From: Maria Tomalova <Maria.Tomalova@arun.gov.uk>
Sent: Wednesday, September 13, 2023 5:52 PM
To: Planning.Responses <Planning.Responses@arun.gov.uk>
Subject: FW: Stakers Farm

Please upload the below to the applications Y/105/19 and Y/106/19: Planning Correspondence.

From: Martyn White <Martyn.White@arun.gov.uk>
Sent: Thursday, June 18, 2020 11:07 AM
To: Maria Tomalova <Maria.Tomalova@arun.gov.uk>
Subject: RE: Stakers Farm

Drawing Title
Existing and Proposed Elevations - Barn 3

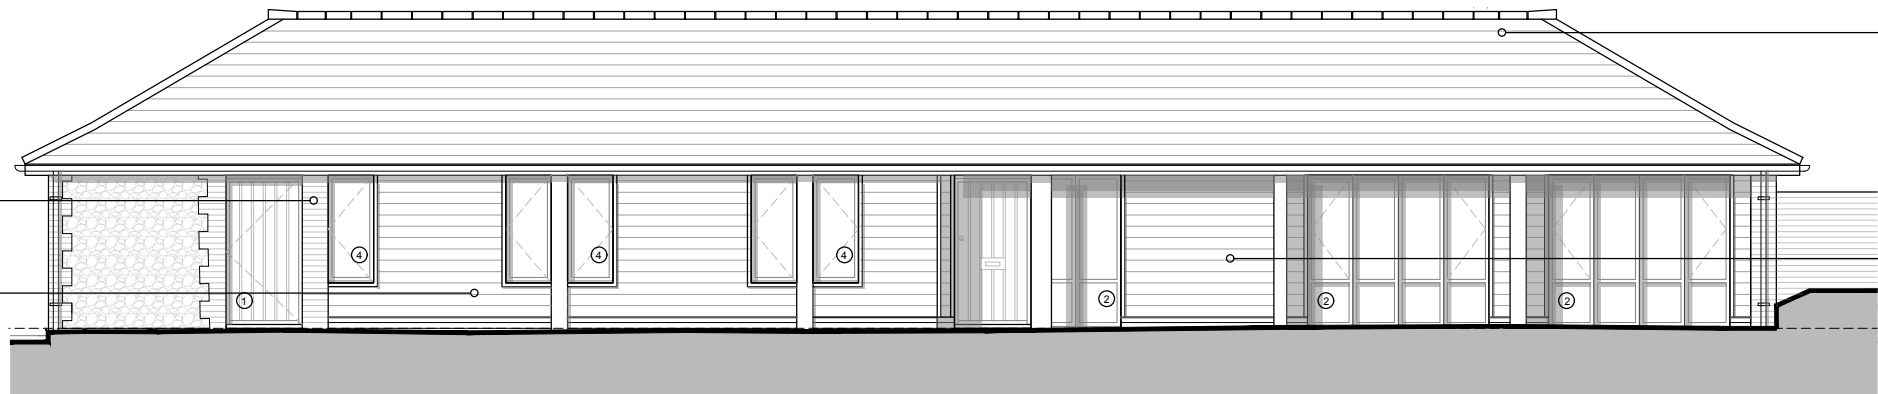
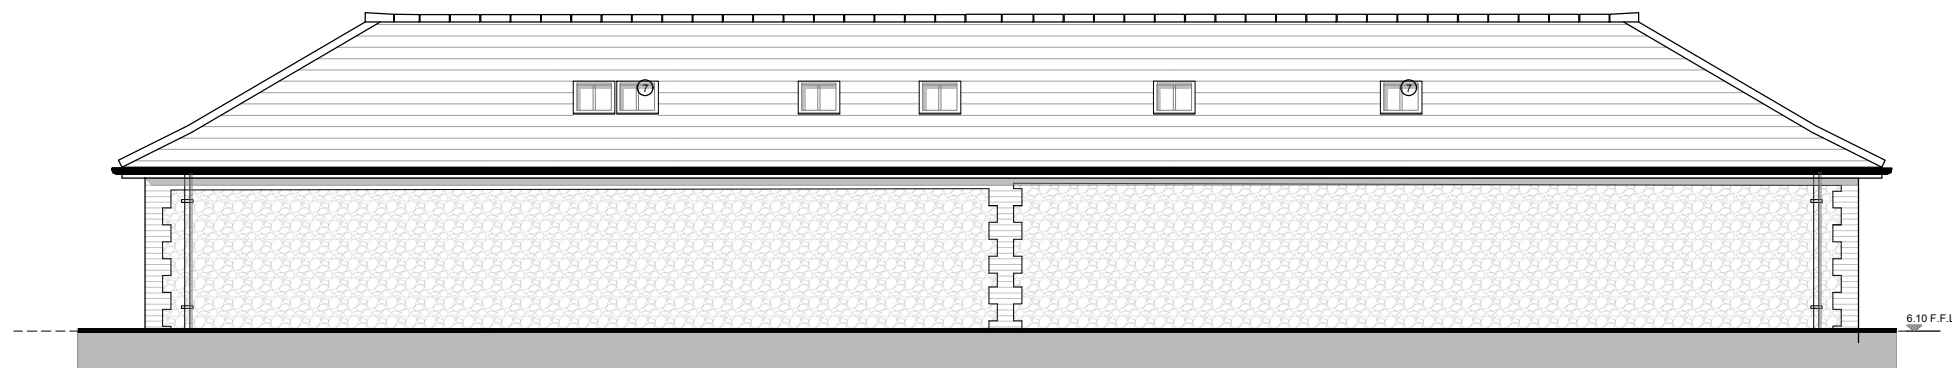
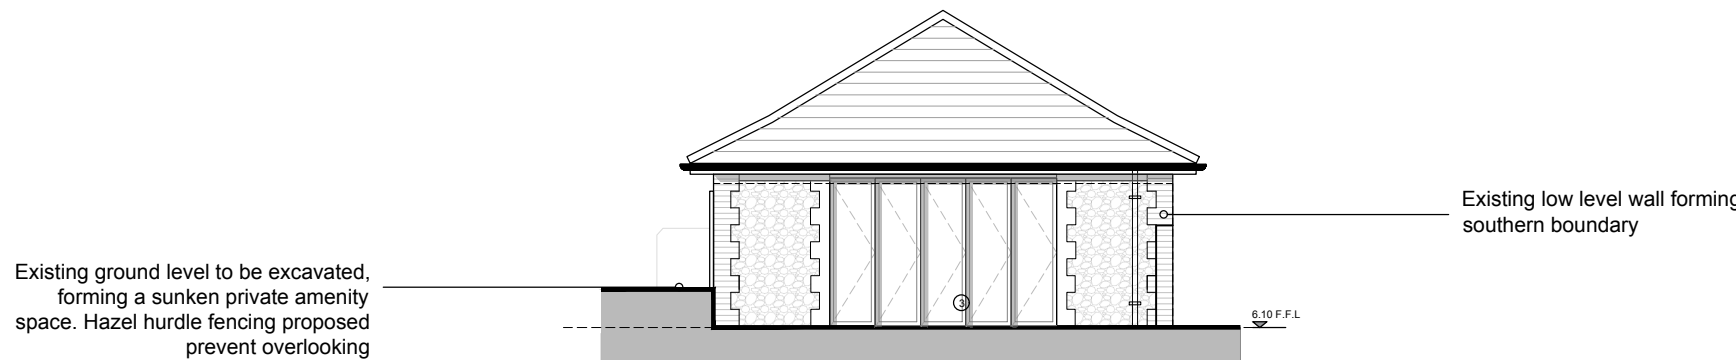
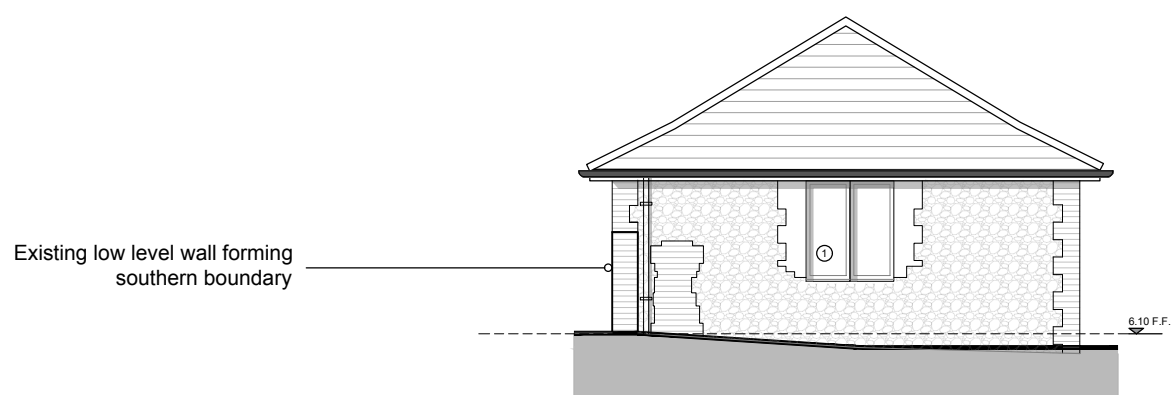
As I recall, no amendments to the drawings were required for this barn – previously there was a bi-folding door, but I believe this is to be removed?

Proposed South Elevation (C)

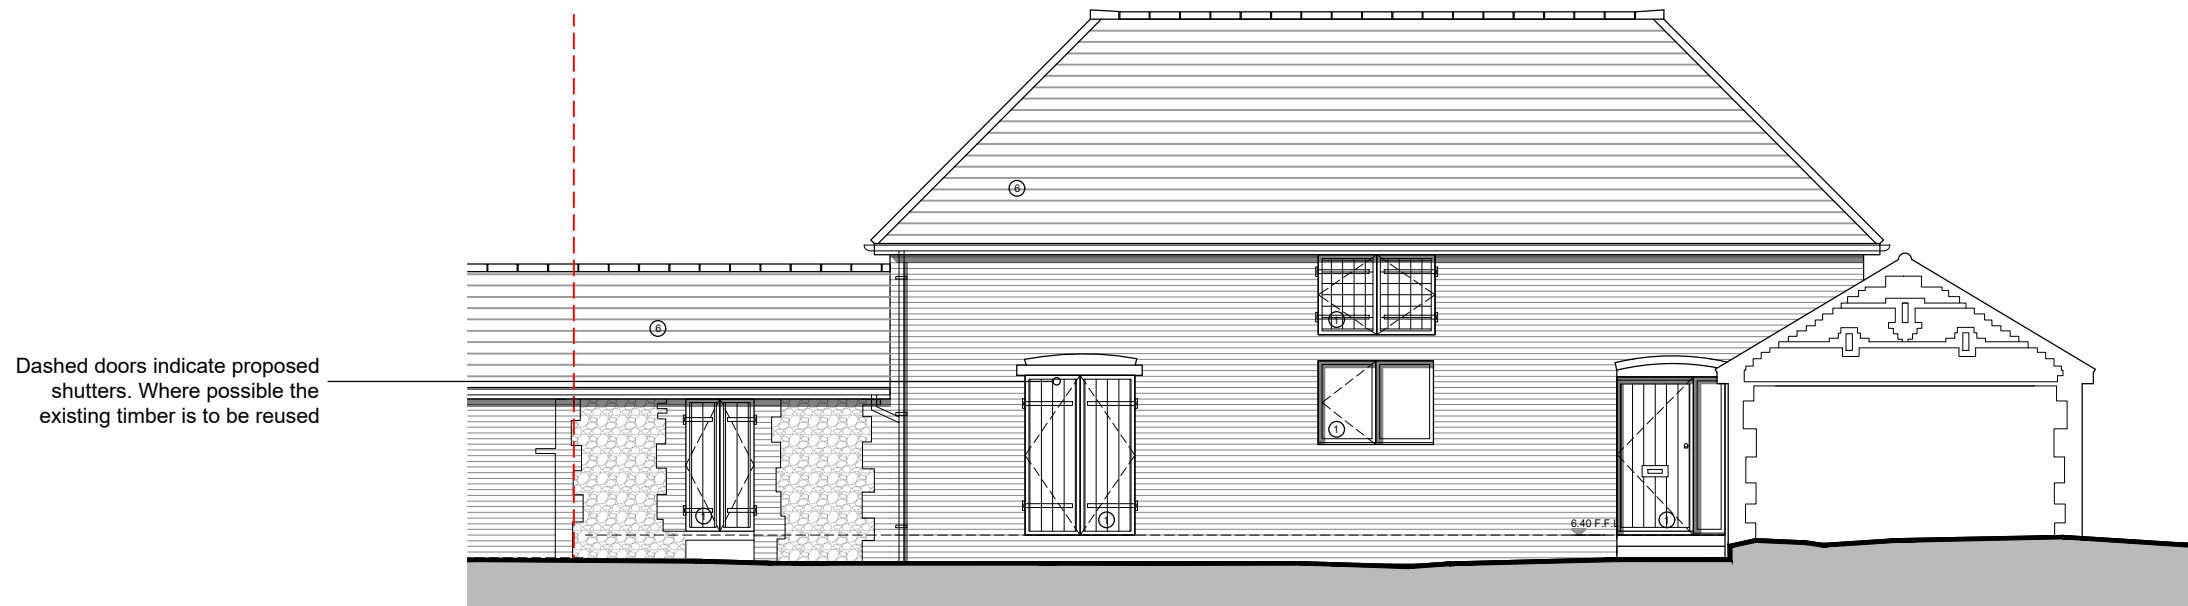
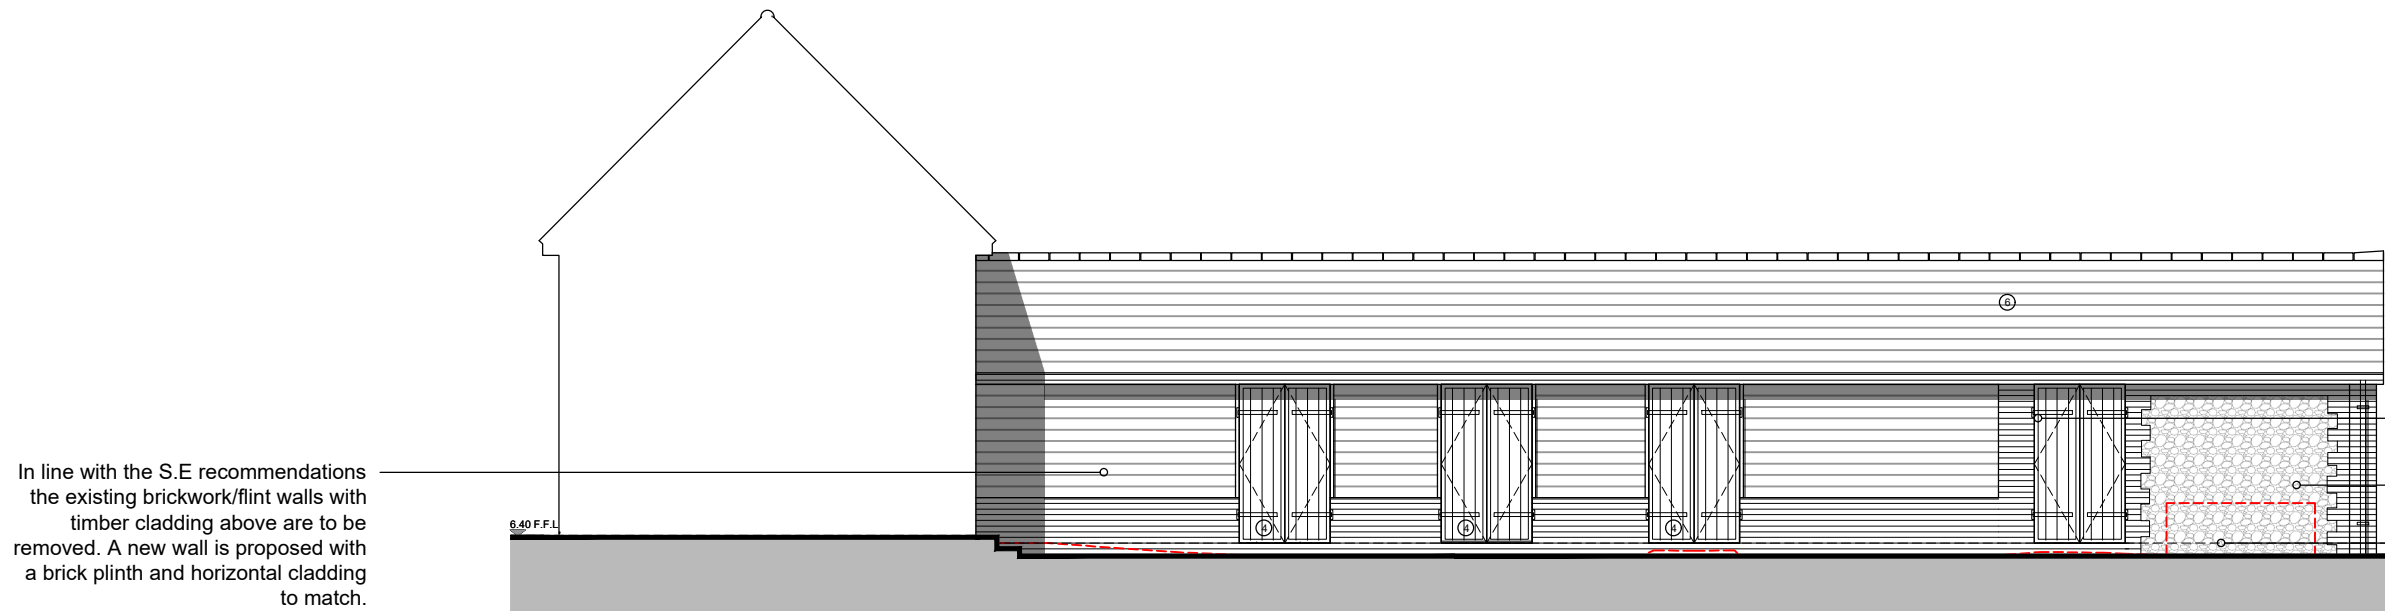
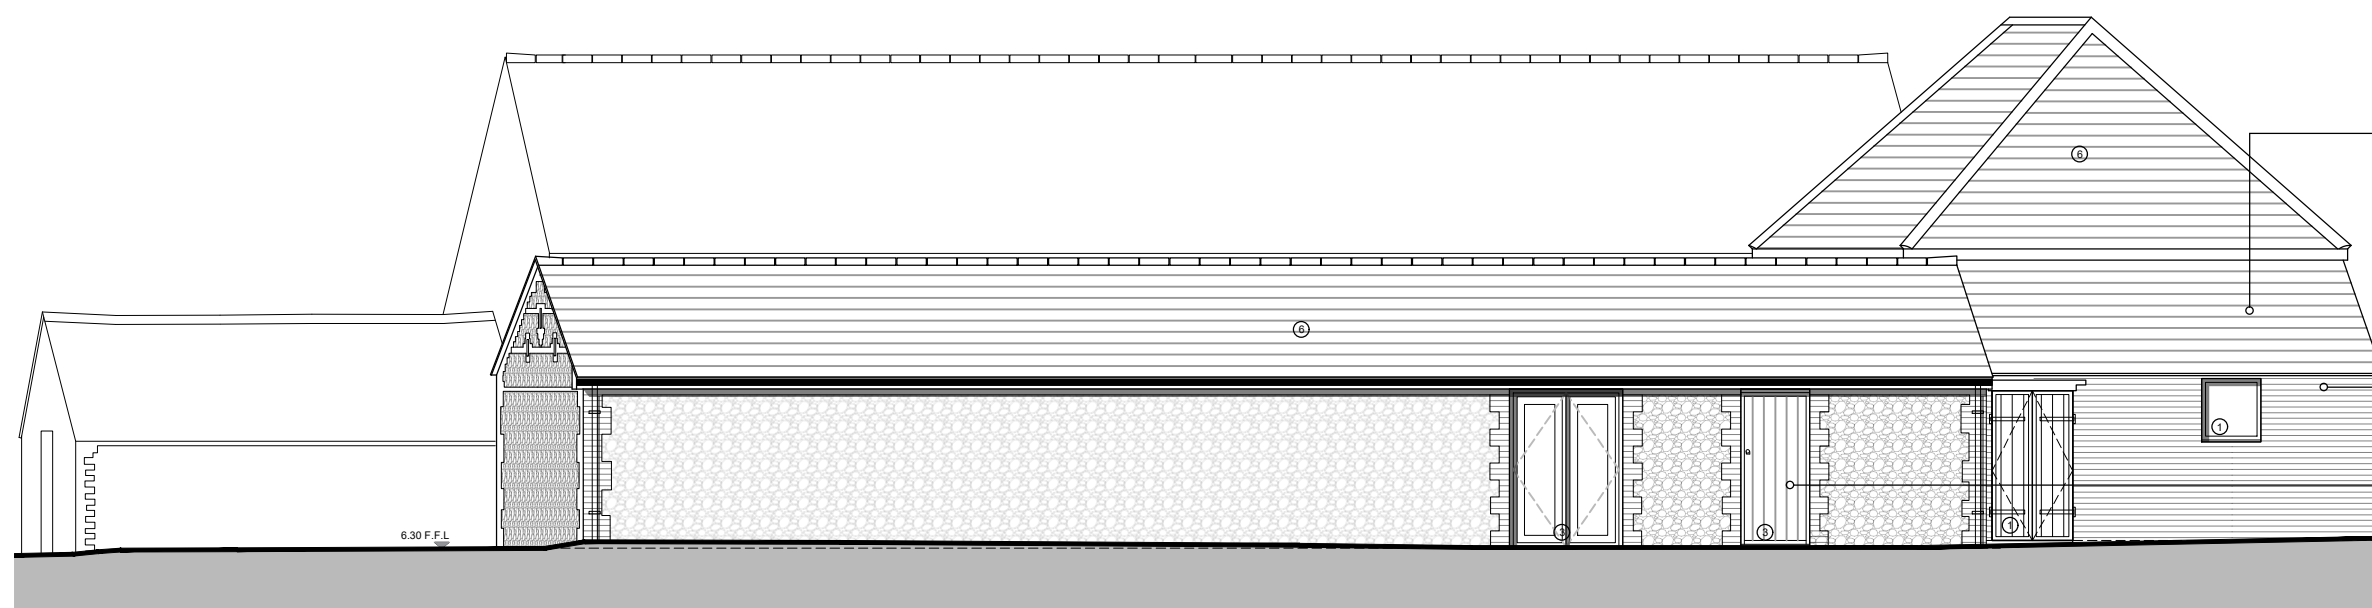
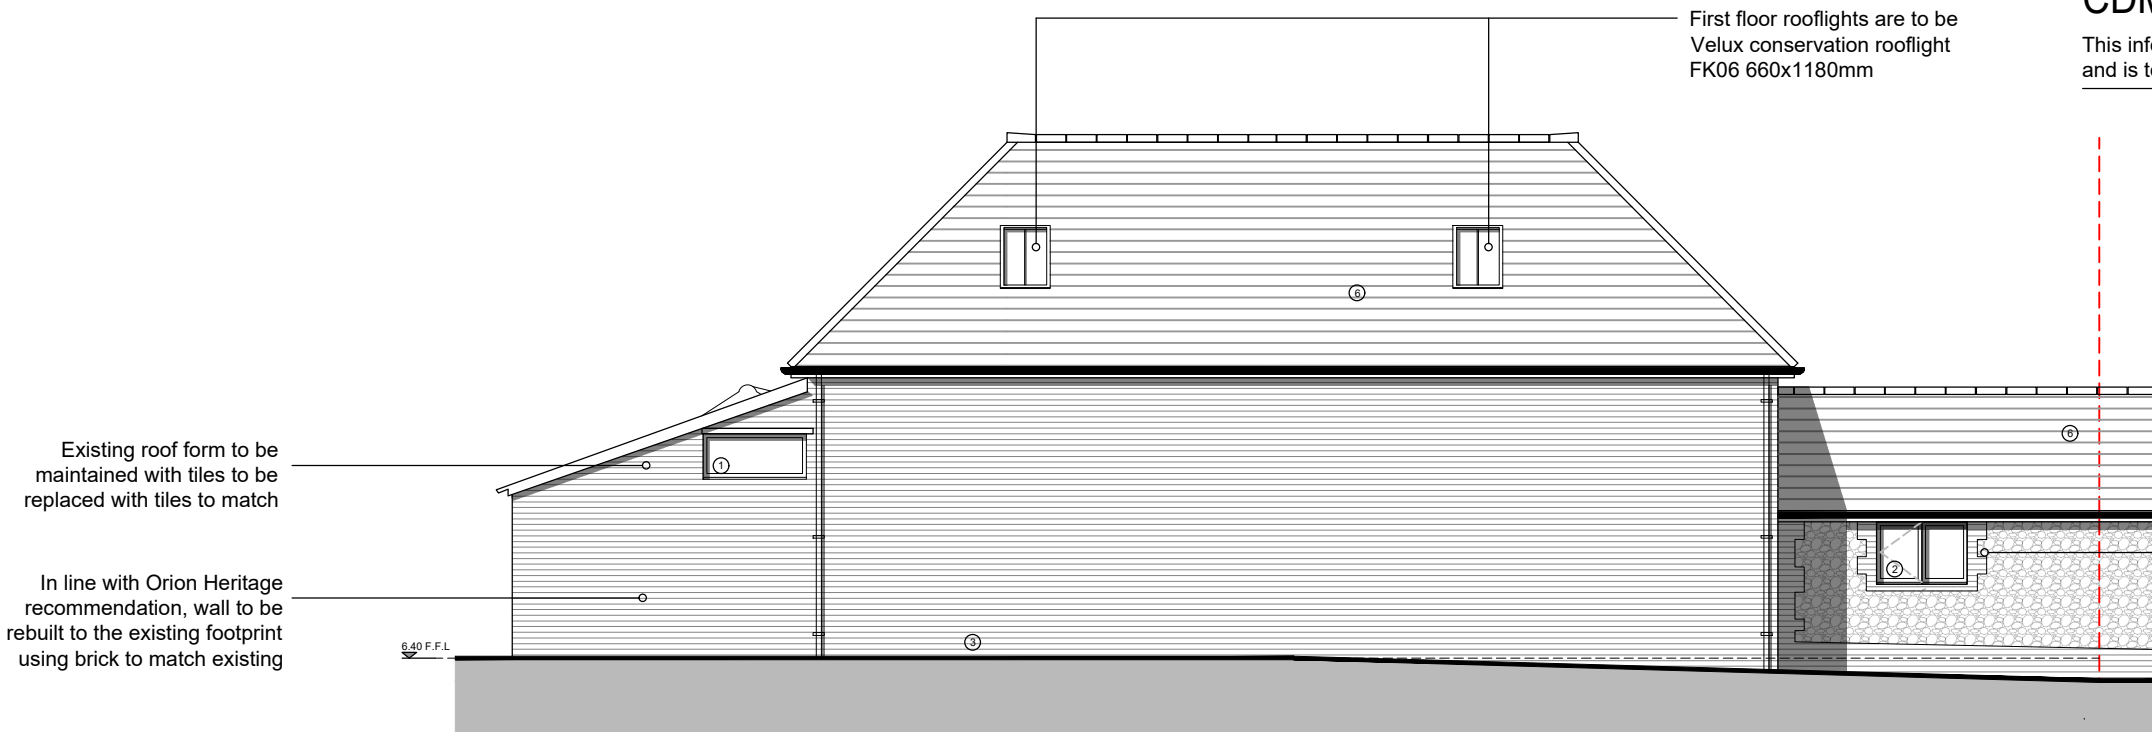
We will remove as many rooflights as possible from this barn. However, we cannot remove all the rooflights as we will need to provide light to the bedroom to make it a habitable space. A roof light will also be required to provide purge ventilation (Part F of Building Regs) otherwise a mechanical system would be needed. Under the Building Regulations we will also need to meet the Daylight and room brightness guidance set within British Standard BS 8206-2:2008 Lighting for Buildings. We will therefore seek to provide the very minimum amount of rooflights necessary to meet Building Regulations and seek to locate them on the least prominent part of the roof. Such an approach would be in accordance with Historic England guidance 'Adapting Traditional Farm Buildings' which states the following:

South elevation – we will amend the proposed alterations to the single storey element and reduce the amount of glazing, ensuring that this elevation is changed as little as possible from the existing situation.

There should be as few rooflights as possible, and these should be placed on the rear elevations where they will not be visible. They should also be of conservation standard

It is not clear how the interior of the barn will be treated, bearing in mind the comments I previously made regarding the interior. This needs careful consideration and more information to be supplied to us
